GLENEAGLE
 SUBDIVISION FIL #2

**DRAINAGE, GRADING &
 EROSION CONTROL
 PLAN**

VR-18-018

MODIFIED TYPE 13 INLET
NOT TO SCALE

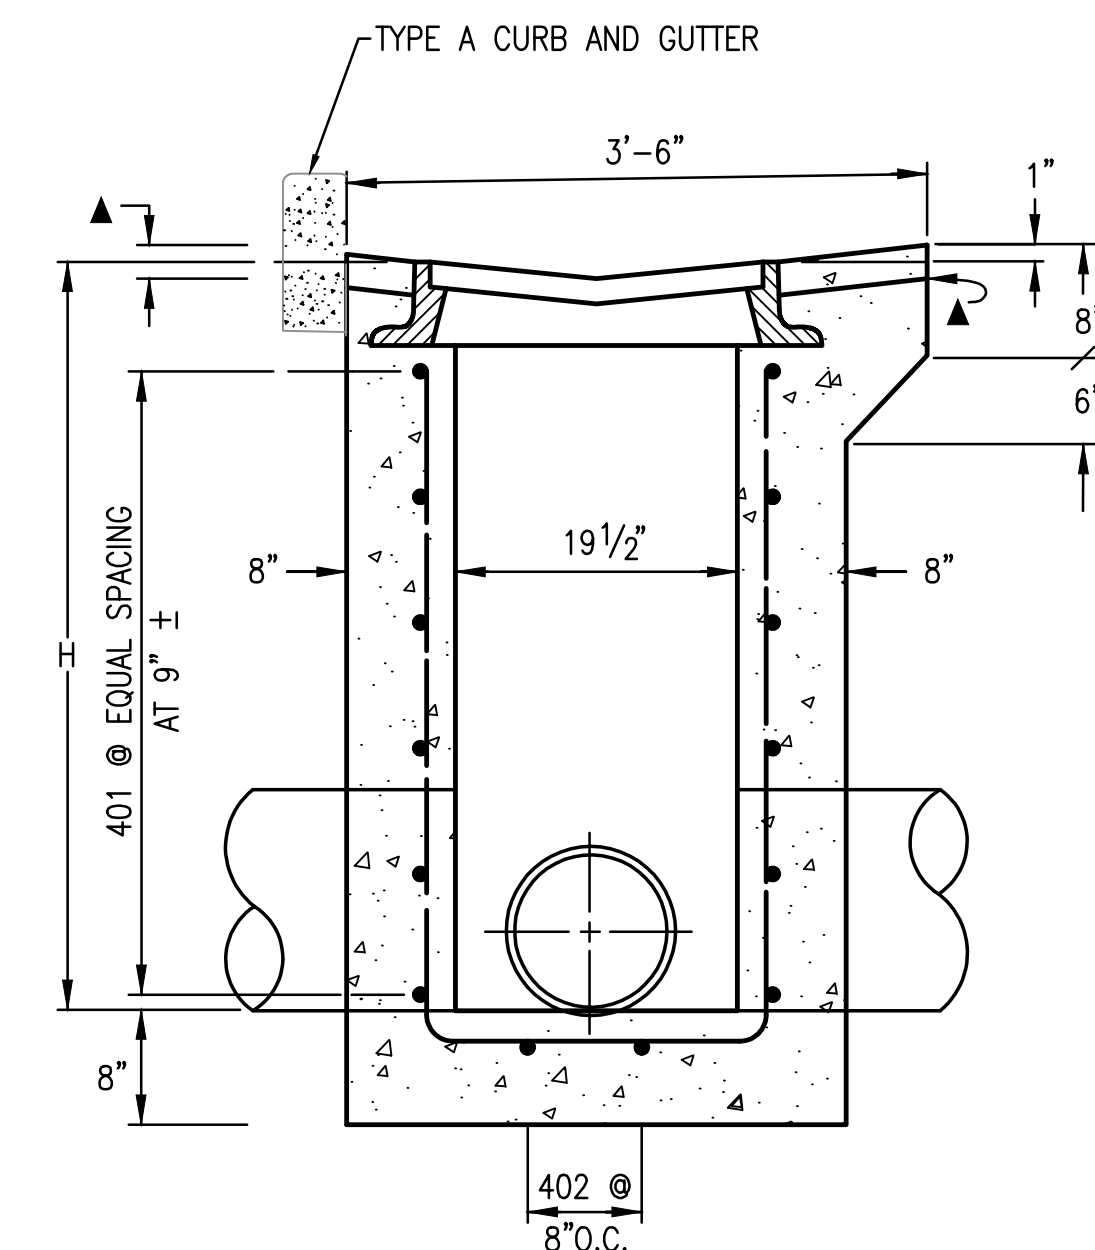
Provide a curb opening inlet. Type R.
or propose a combination inlet such as a Denver
D-16
design. The Modified Type 13 is for a inverted
crown type application.
